MAJOR PROJECT ASSESSMENT:

Residential Project Application

132-138 Killeaton Street, St Ives

MP10_0057

SUMMARY OF PROPOSED AMENDMENTS SK01

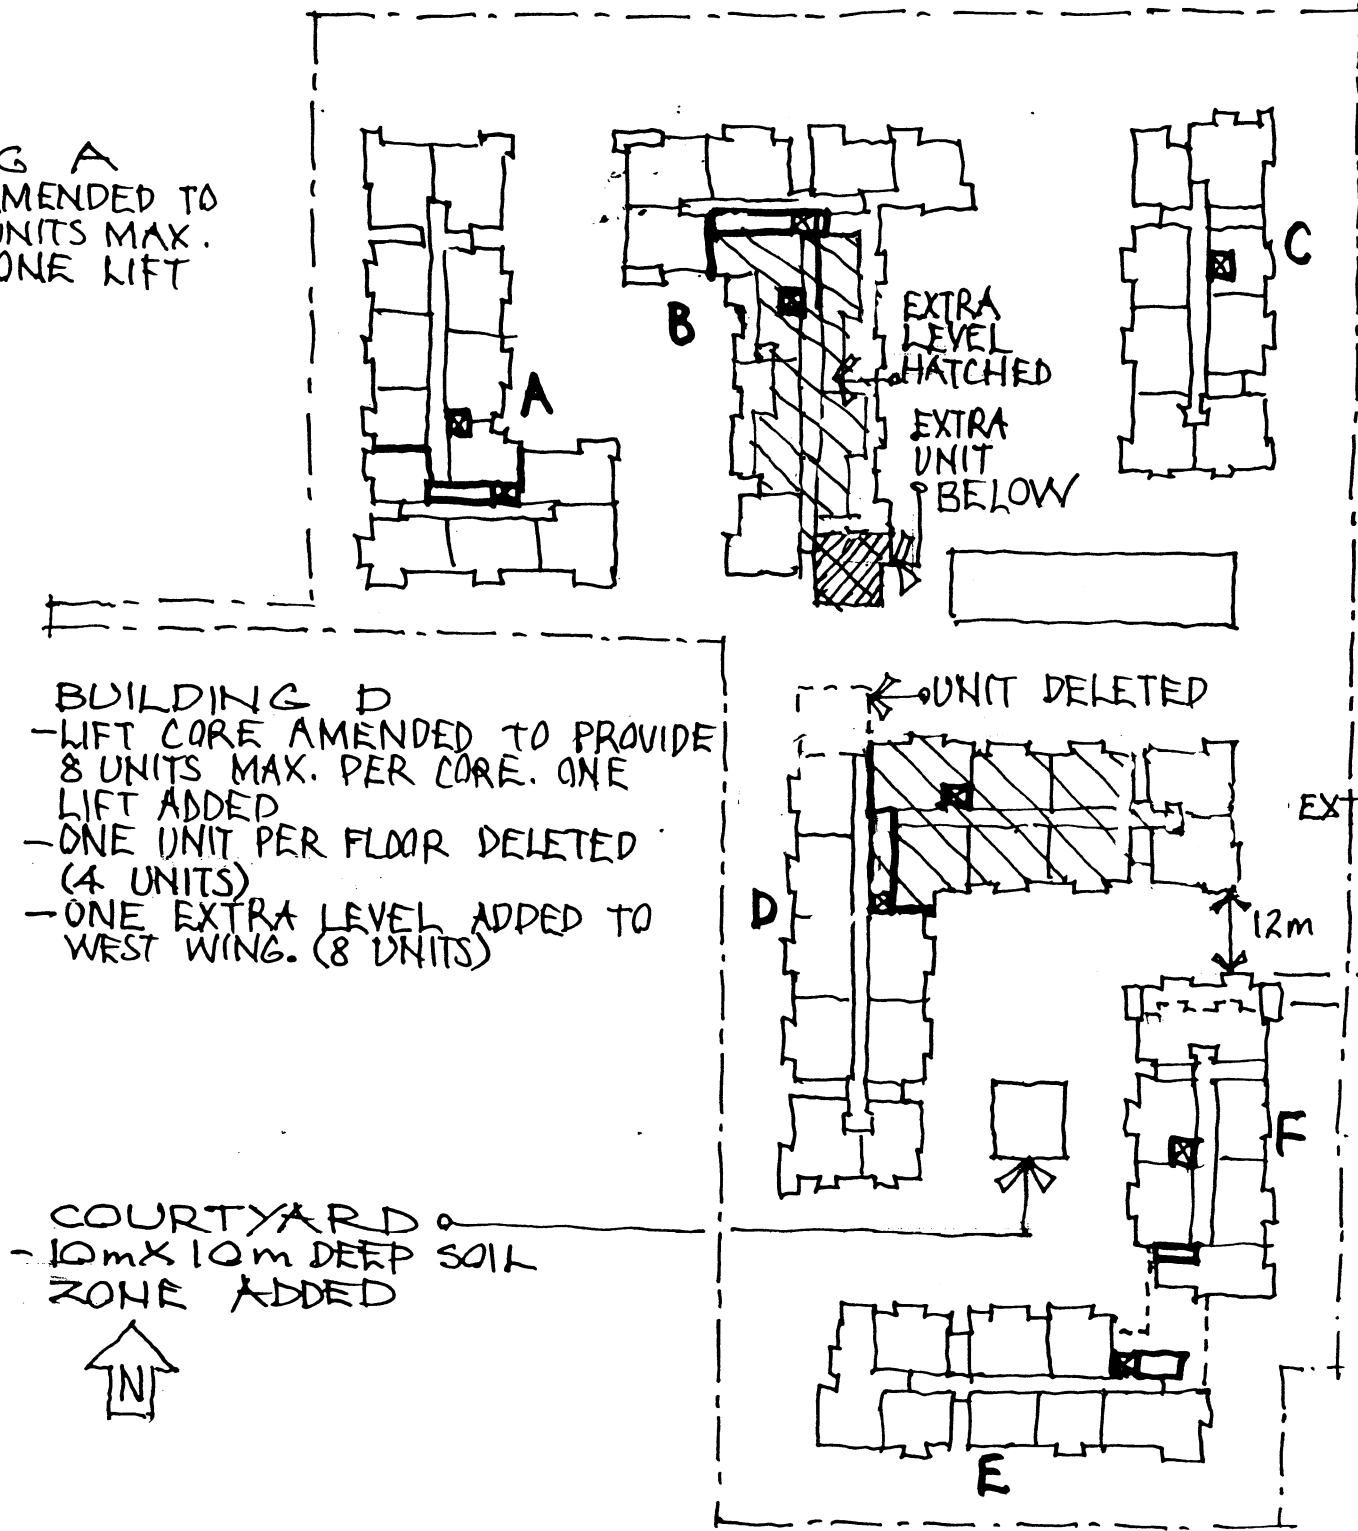
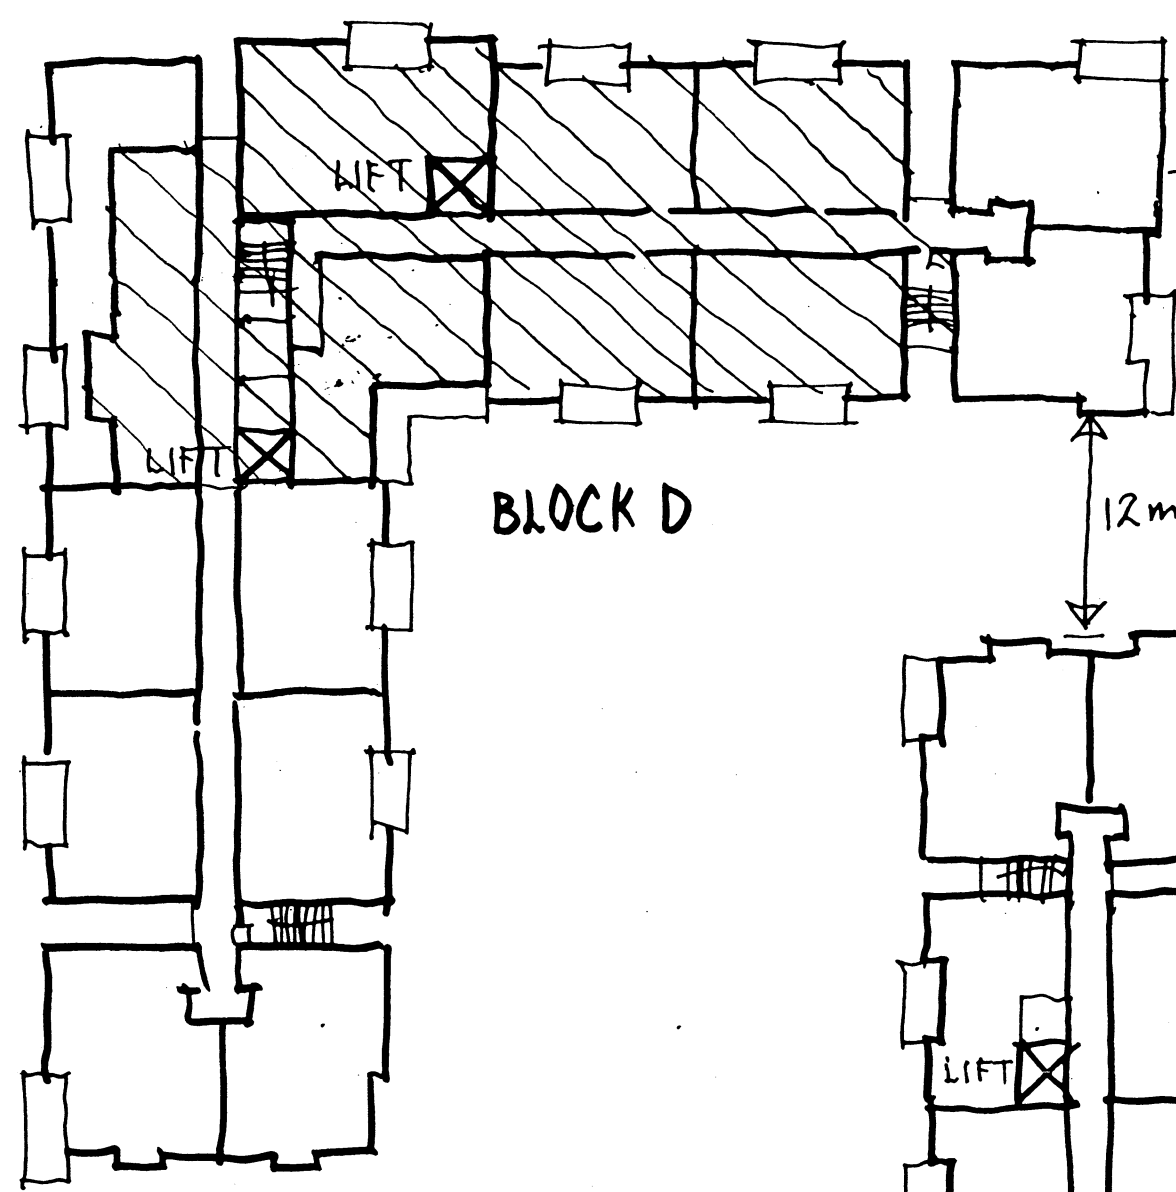
- Redesign of former Building E, an L-shaped building at the southeast (rear) corner of the site, into two smaller buildings known as 'E' and 'F', with a slight northward relocation of Building F;

- Building height in vicinity of the eastern (side) boundary reduced to four storeys with the deletion of 1 storey (8 apartments) from Building C and 1 storey (7 apartments) from (the newly created) Building F (former Building E);

- Increased building footprint and addition of 4 apartments to the south wing of Building B, and new part-level of 8 apartments added above the south wing (resulting in a part 5/part 6 storey building);

- Reduced building footprint and deletion of 4 apartments from the north wing of Building D, with a new part-level of 8 apartments added above the west wing (resulting in a part 5/part 6 storey building);

- Additional lift cores added to Buildings A, B, D and E to achieve compliance with the Residential Development Flat Code requirement of a maximum of 8 dwellings per core;

- Additional 176m² of deep soil landscaped area including a 10 x 10 metre deep soil zone in the central courtyard and subsequent changes to the landscape design; and
